Mallard Pass Solar Farm

**Applicants Response to
Interested Parties' Deadline 2
Submissions - Traffic and
Transport**

Deadline 3 - June 2023

EN010127/APP/9.26

**DWG. NO 4990-2001-T-026-D**

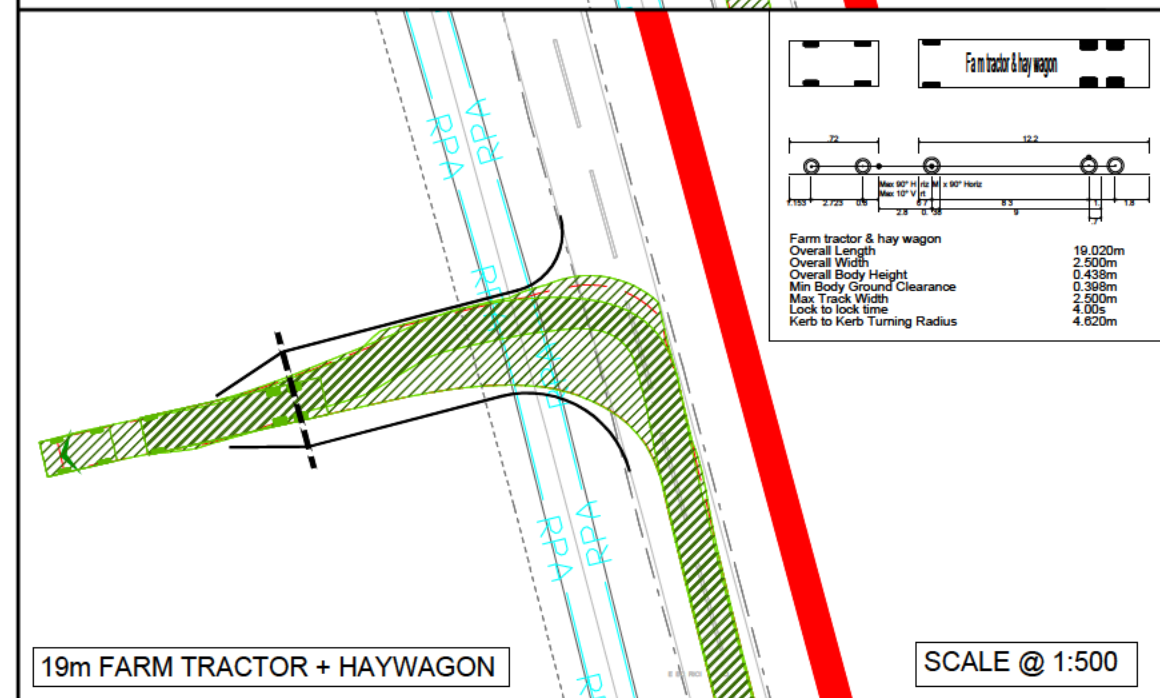
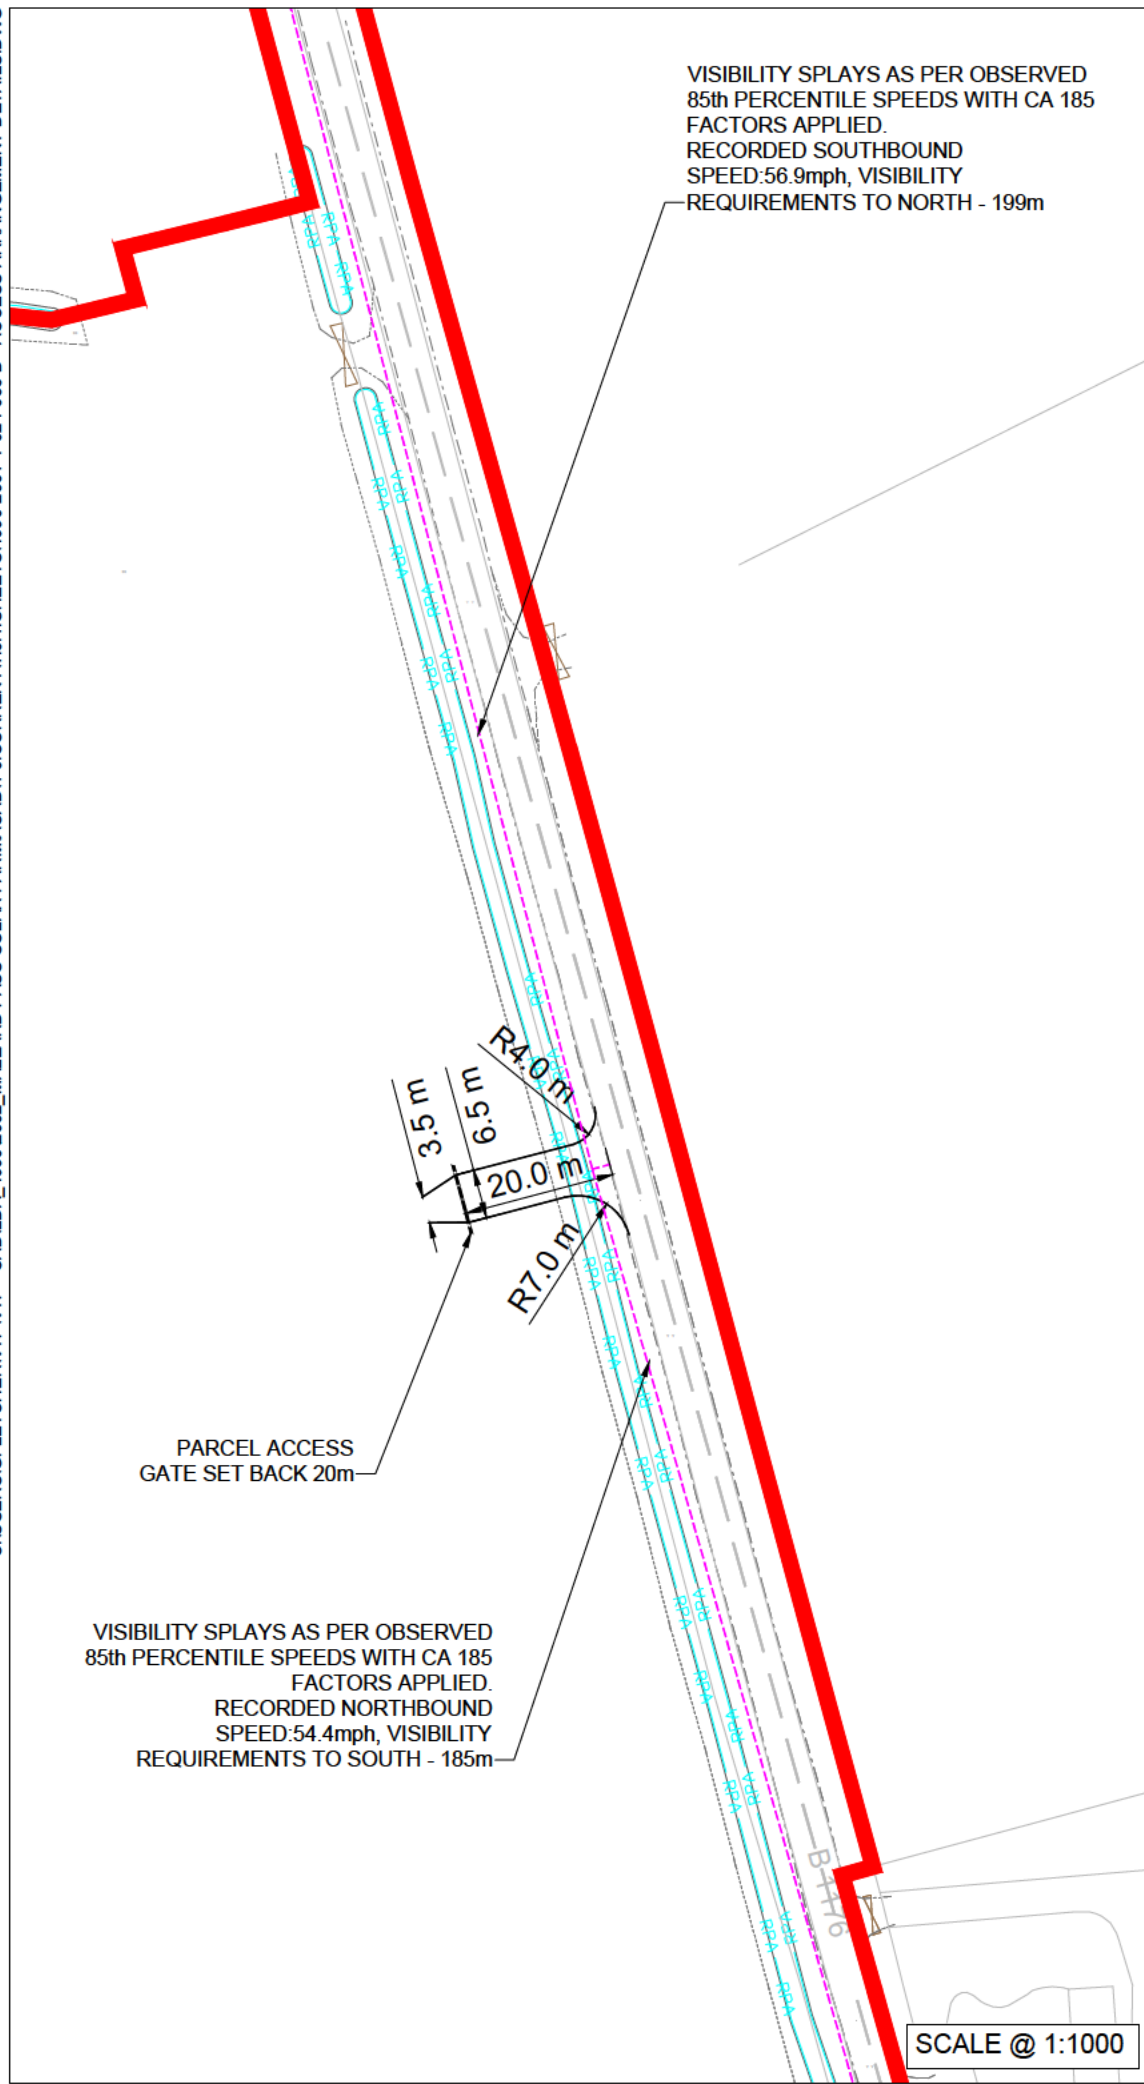
<p>REP2-169</p>		<p>Concern that the site access on Carlby Road is located on a bend in the road making it dangerous.</p>	<p>The access onto Carlby Road is proposed to be relocated in order to ensure that appropriate visibility splays could be achieved in accordance with the DMRB requirements. A Stage</p>

Parties Raised	Sub-Theme	Issues Raised	Applicant's Response
			<p>1 Road Safety Audit (RSA) was carried out for this access proposal which raised no issues or concerns, other than the need for a cyclic and regular vegetation maintenance scheme as set out in the oLEMP [REP2-022], which will be secured by way of requirement on the DCO through the CTMP and LEMP. The access proposals in this location have also been discussed and agreed with the Local Highway Authority.</p>
REP2-169		<p>Concern over proposed access track running over existing drainage. Feels it would be better to maintain the existing track and make sure it is capable of taking the abnormal heavy loads (as it does today), than change the road layout to a more dangerous position on the bend which would require the removal of any trees and hedgerow on the north edge of Carlby Road.</p>	<p>The access junction onto Carlby Road has been relocated to ensure that there is sufficient visibility splays in accordance with the DMRB requirements for all vehicle types that will require it, which is an improvement from the existing position as the current arrangement does not comply with the DMRB visibility requirements. Highway safety is considered to be a priority in this instance and on that basis it is proposed to relocate the access, as per the current proposal.</p>
